**Consultation Response from KC,
Highways Development Management****2024/92768 land rear of, 23, Dalton Fold Road, Dalton, Huddersfield, HD5 9NL****Outline application for erection of one dwelling****Date Responded: 19-11-2024.****Responding Officer: Mark Berry.****Responding Ref: 5-11SE-6.**

This is an outline application for the erection of one 2 bedroomed detached dwelling (with access and layout the matters to be considered) at land to the rear of, 23, Dalton Fold Road, Dalton, Huddersfield.

Existing Block Plan

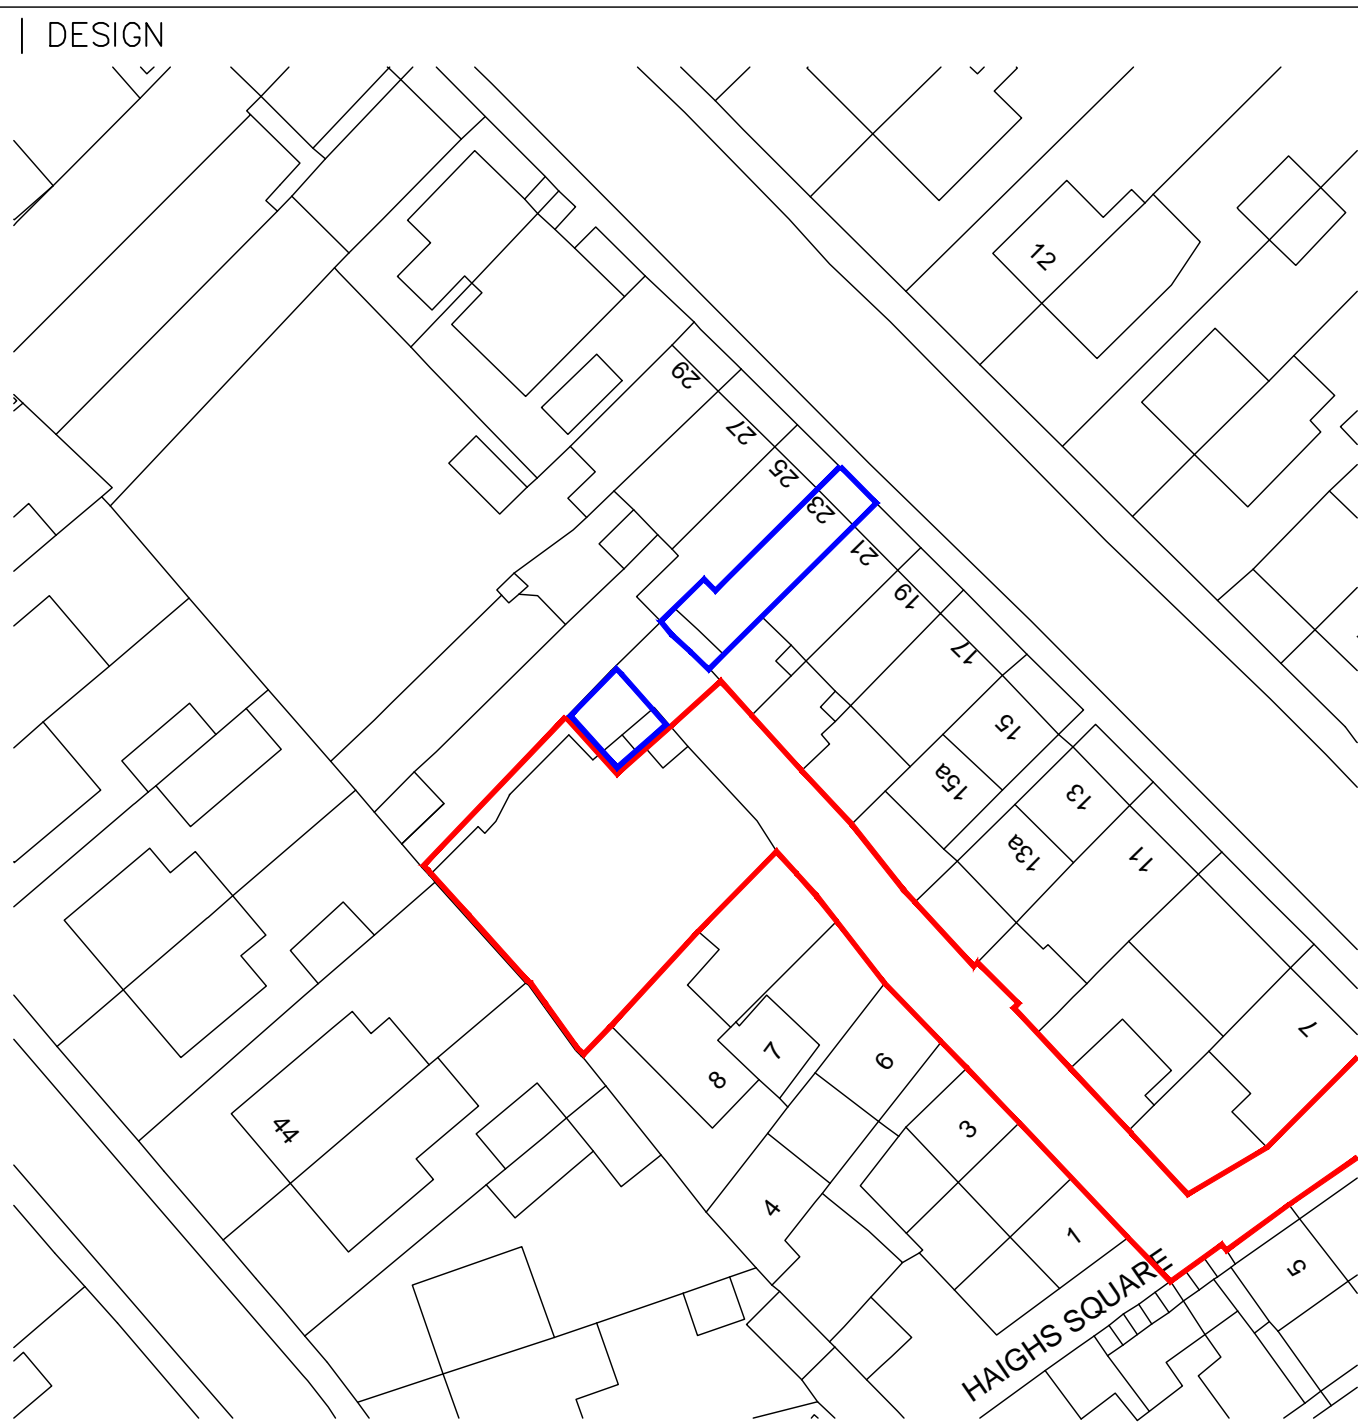
This application site is the garden/allotment to the rear of 23 Dalton Fold Road. This area also contains the parking area to 23 Dalton Fold Road.

Access is from Dalton Fold Road via an existing track to the rear 7 to 23 Dalton Fold Road.

1, The existing access track is severely sub-standard being narrow (not wide enough for 2 vehicles to pass), un-made, there are also no footways, drainage or street lighting and there is no turning head.

Site Block Plan as Proposed

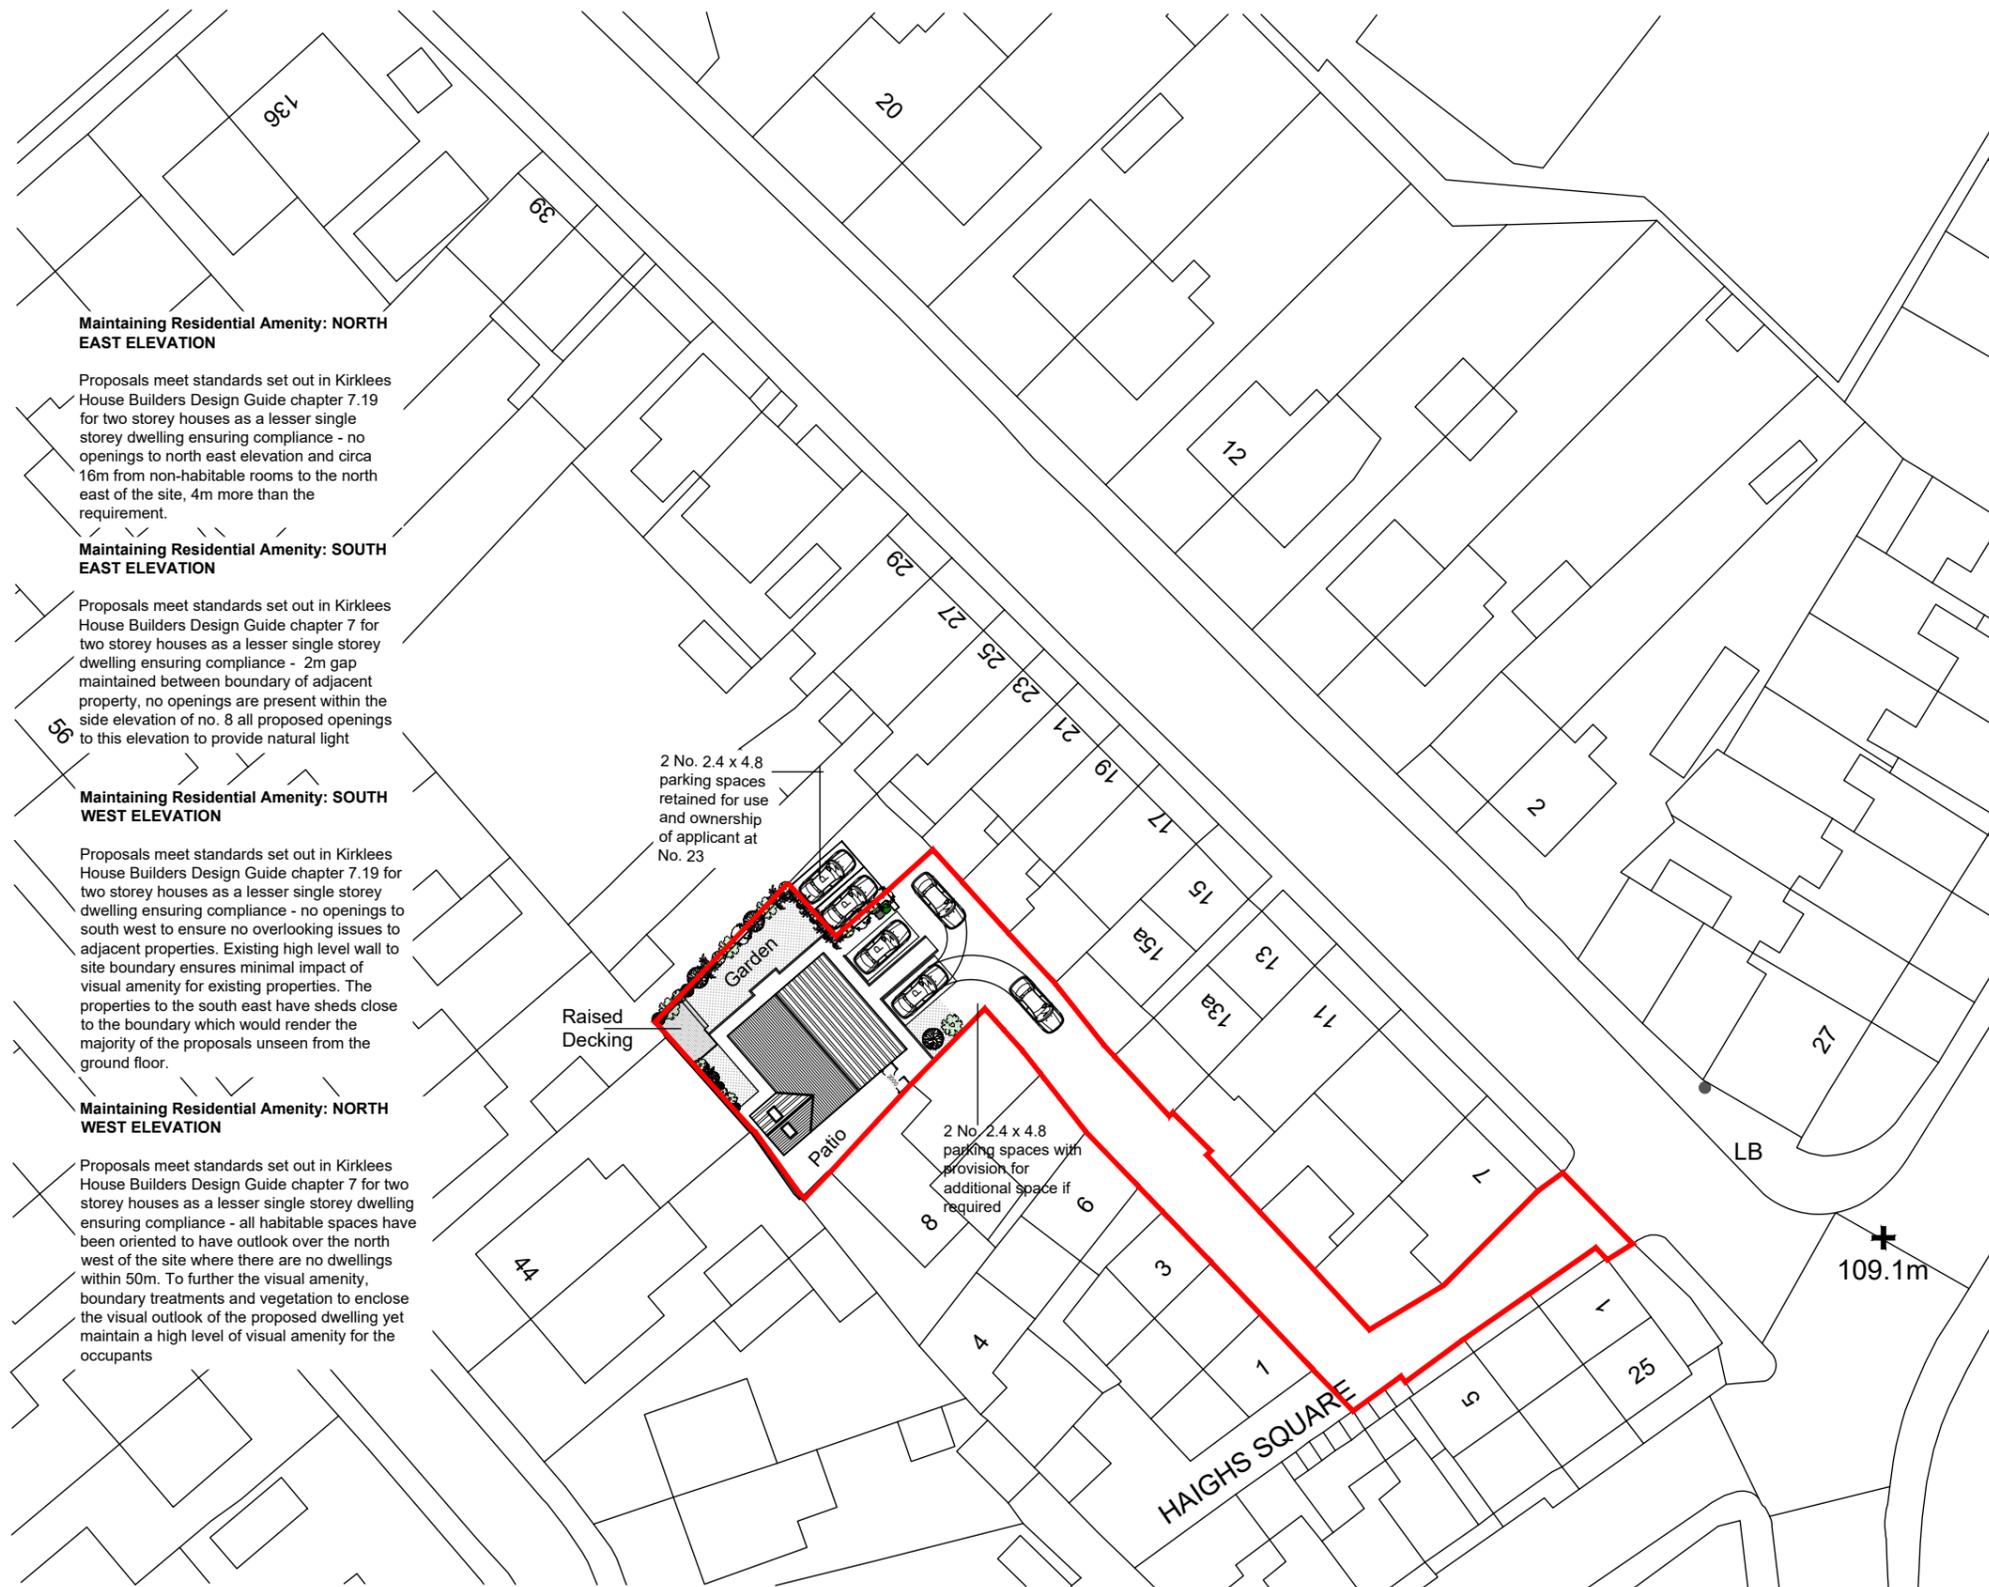
The proposals show a detached dwelling with 2 off-street parking spaces to the front and 2 further spaces retained for number 23.

In this case the access track is more than 45m in length and there are no fire tender turning facilities.

There is no access or turning facilities for a refuse vehicle and the bin presentation point would therefore have to be at the junction with Dalton Fold Road which is more than the recommended 25m from the storage point.
